Appendix A – Response to DPHI RFI

Table 1 Response to matters raised by Department of Planning, Housing and Infrastructure (DPHI)

HEIGHT PLANE DIAGRAM

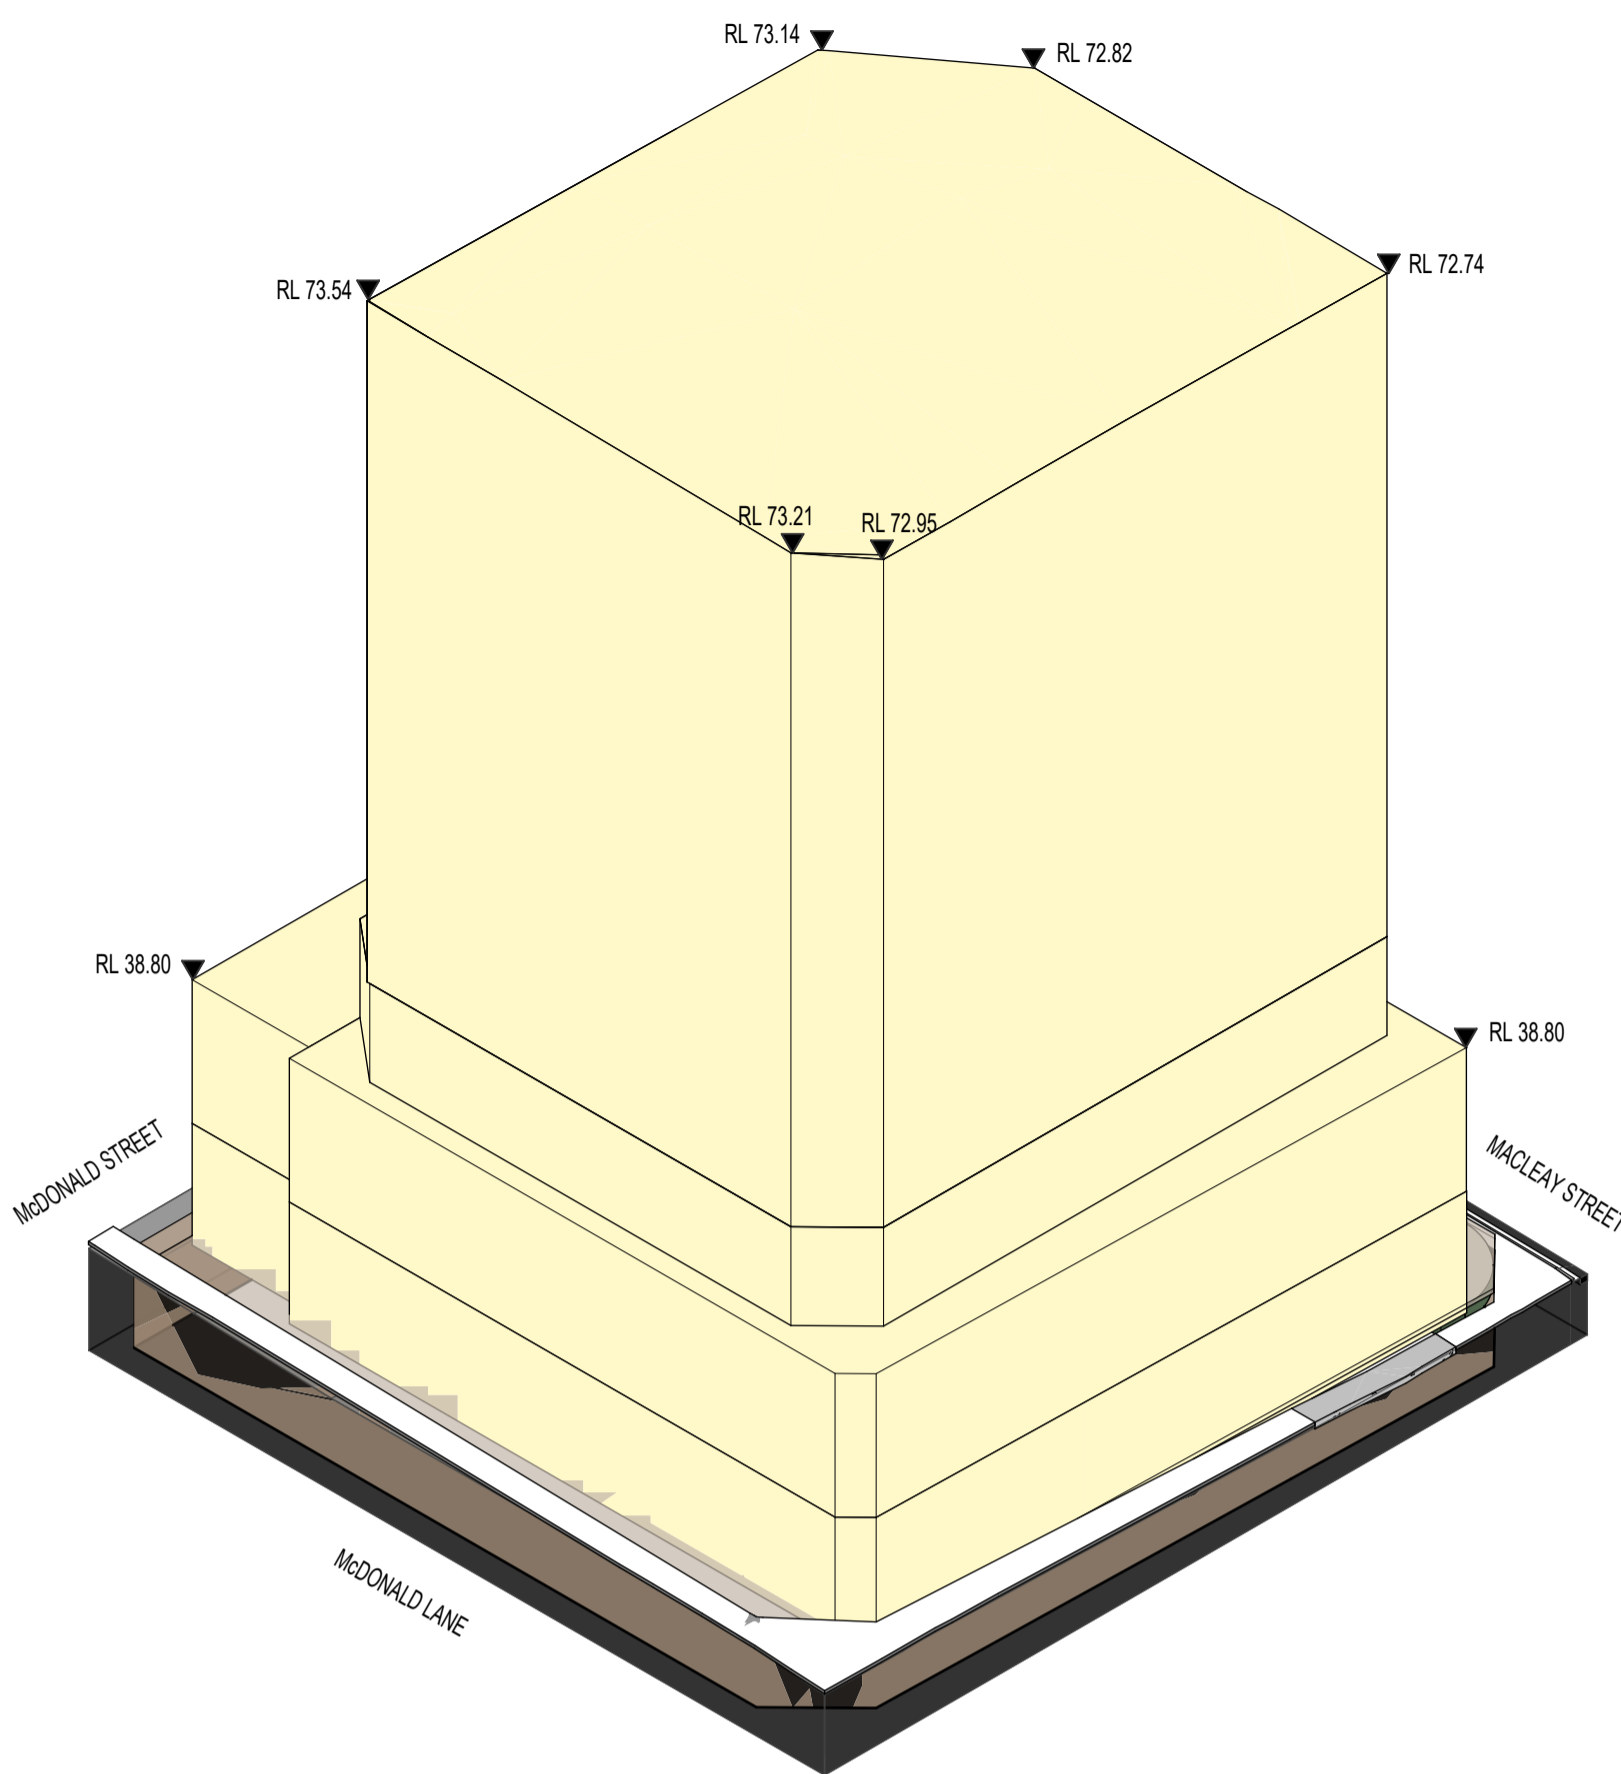
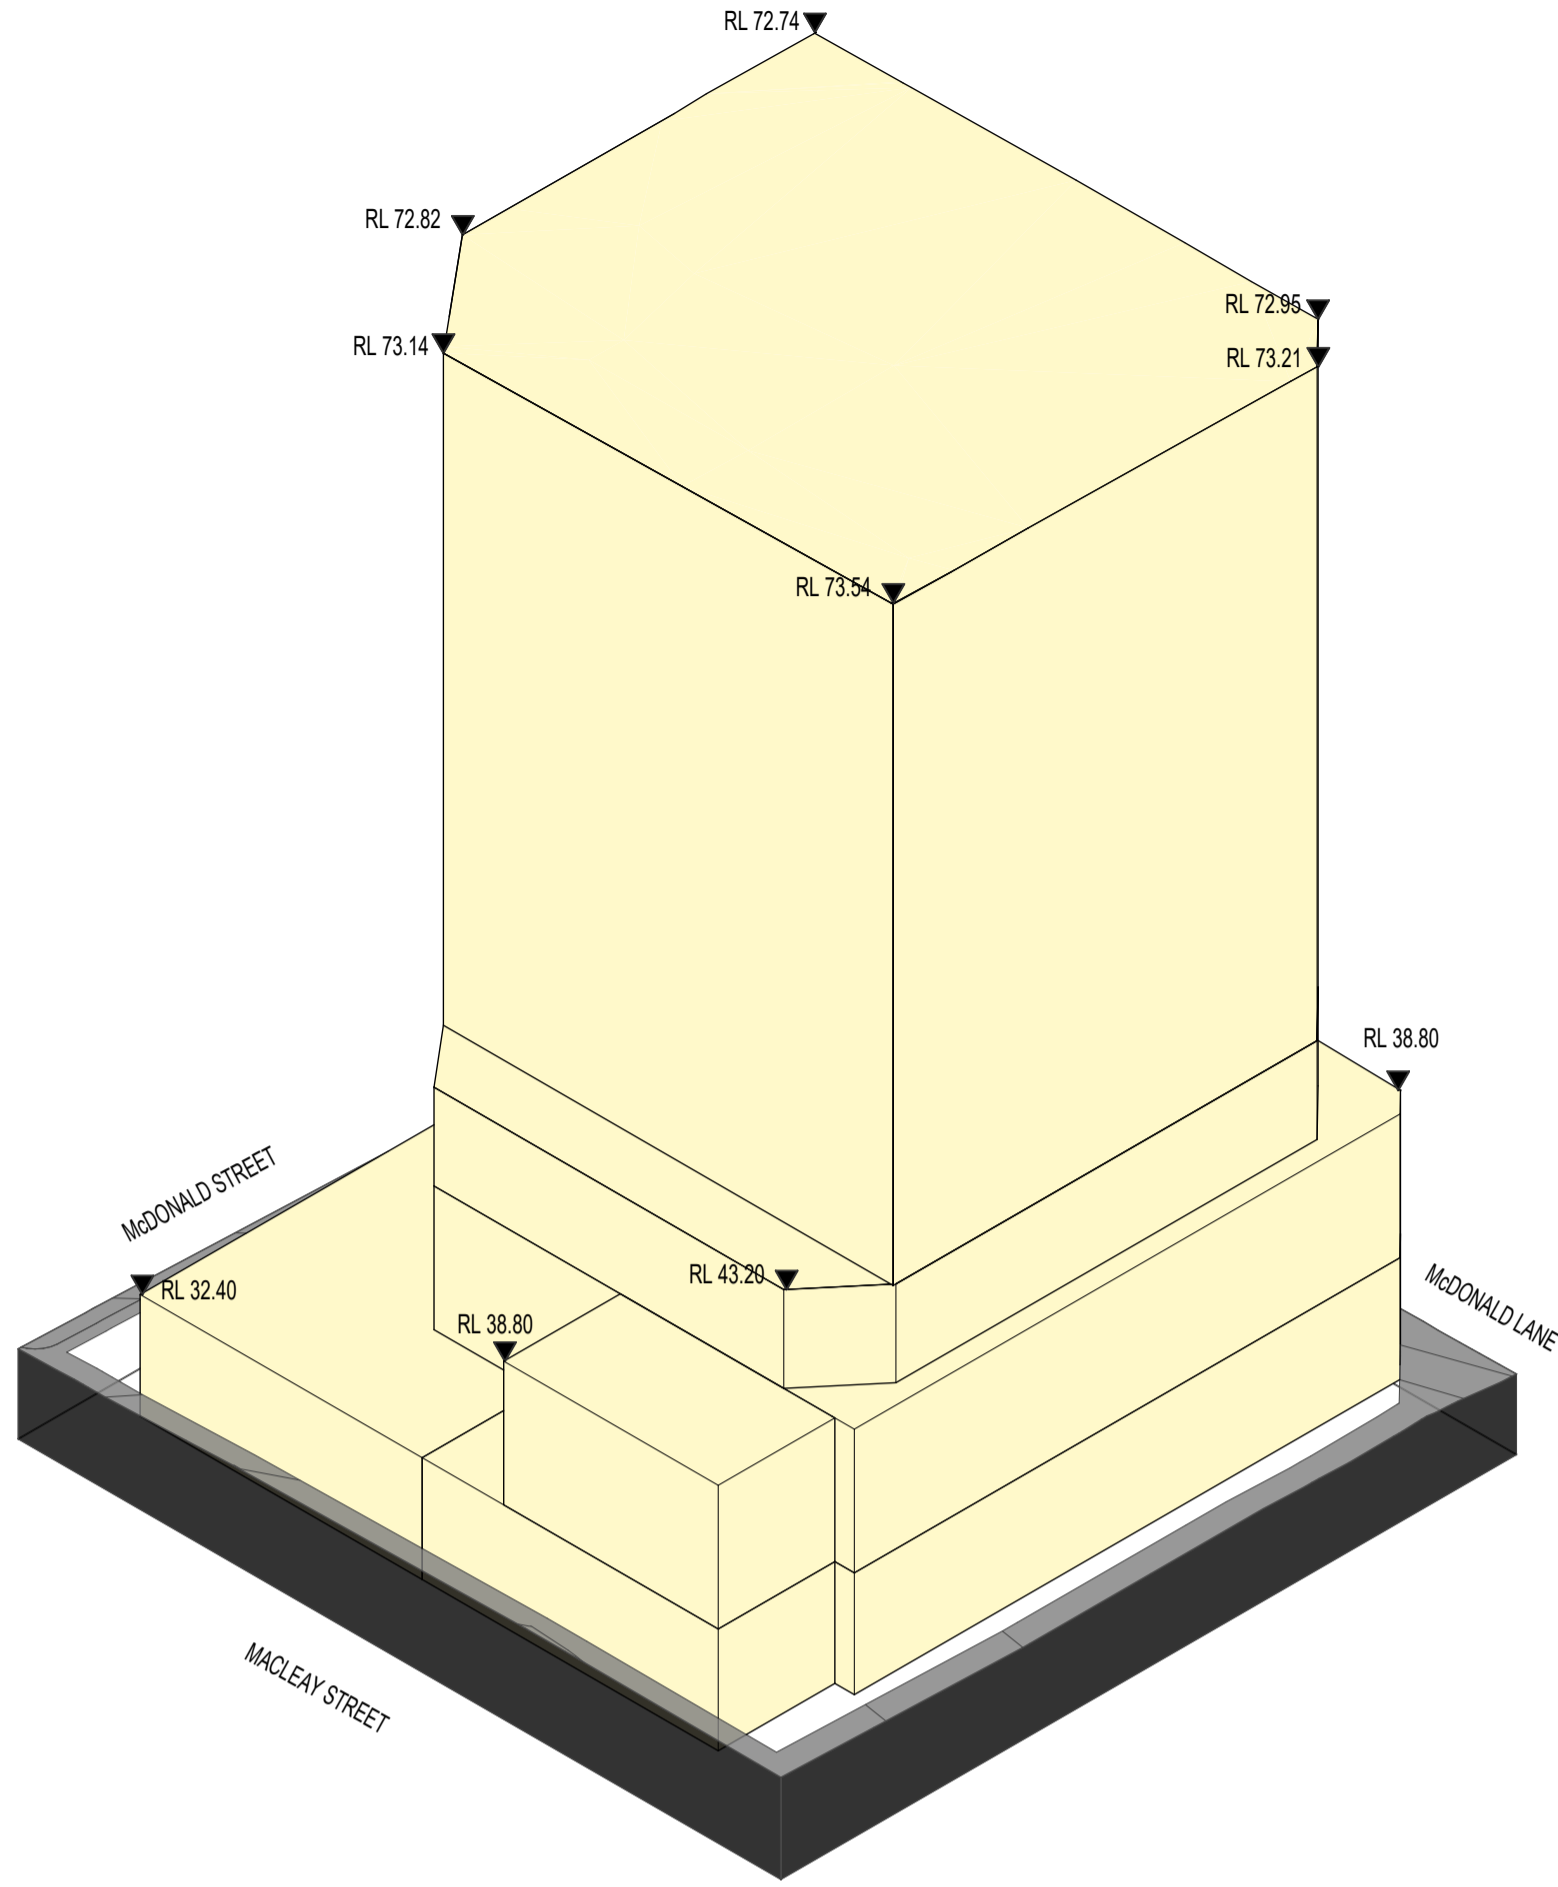
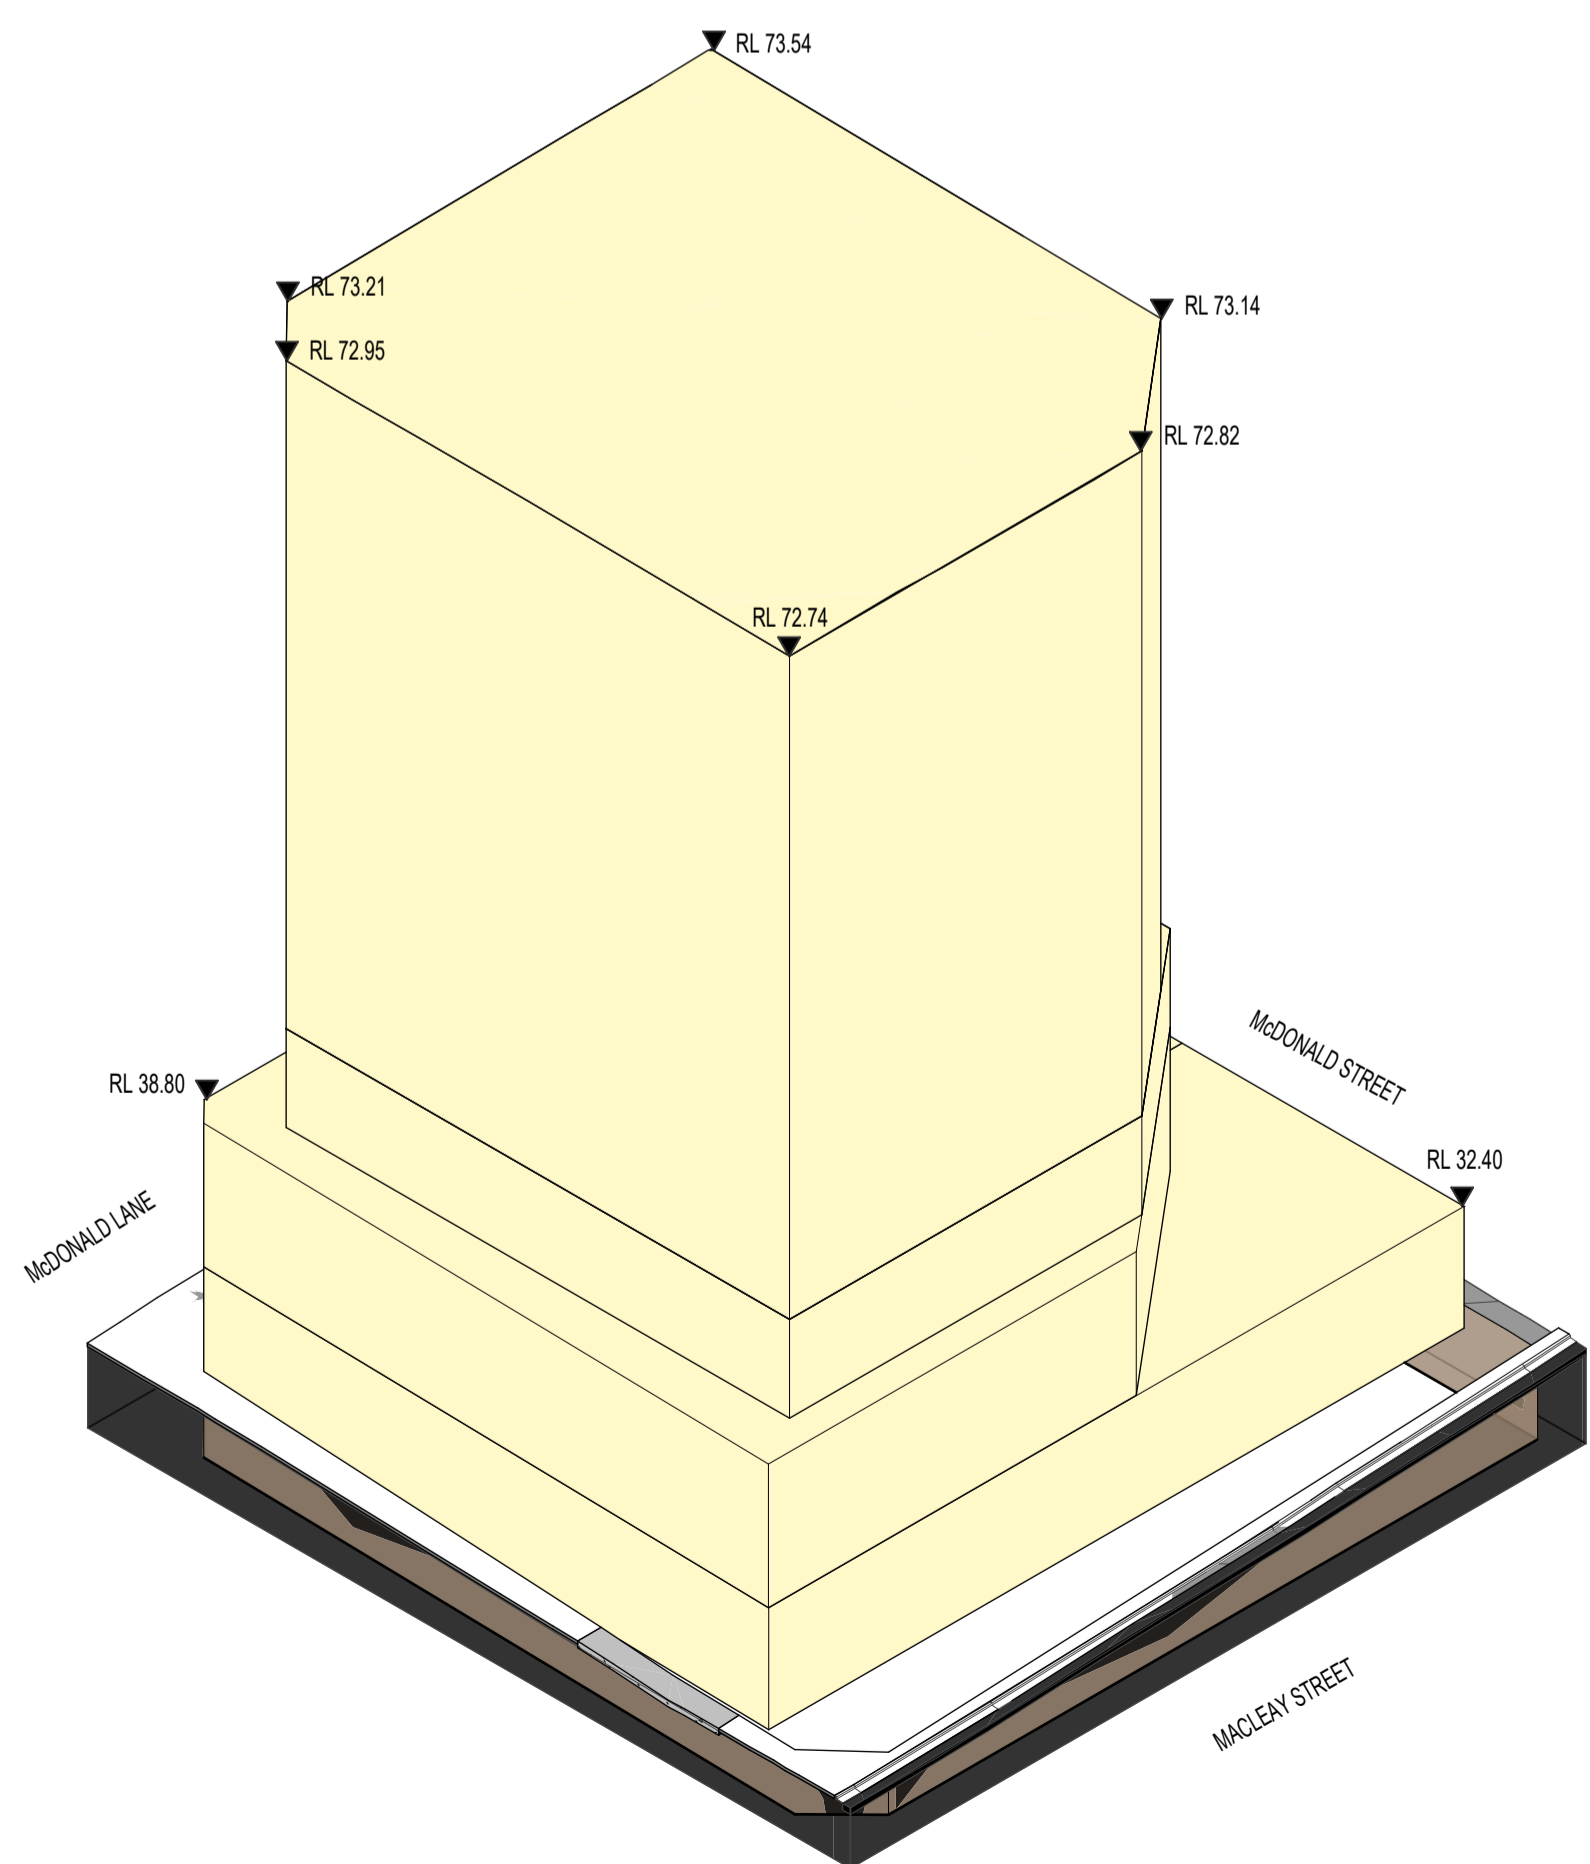
(b) Indicate the location and area of deep soil zones on the site plan.	The deep soil zone is proposed to be located along McDonald Lane and has been depicted in the updated Site Plan at Appendix B.	Appendix B
(c) Align the basement setbacks between the site plans and elevations. Specifically, the 2m eastern setback and the 3.8m western setback to the basement depicted on the site plan are not accurately depicted on the elevations.	The envelope elevation plans have been updated to show the basement setbacks at Appendix B.	Appendix B
(d) Detail the street names/frontages on the height plan diagrams.	Amended height plane diagrams containing street names have been provided at Appendix B.	Appendix B
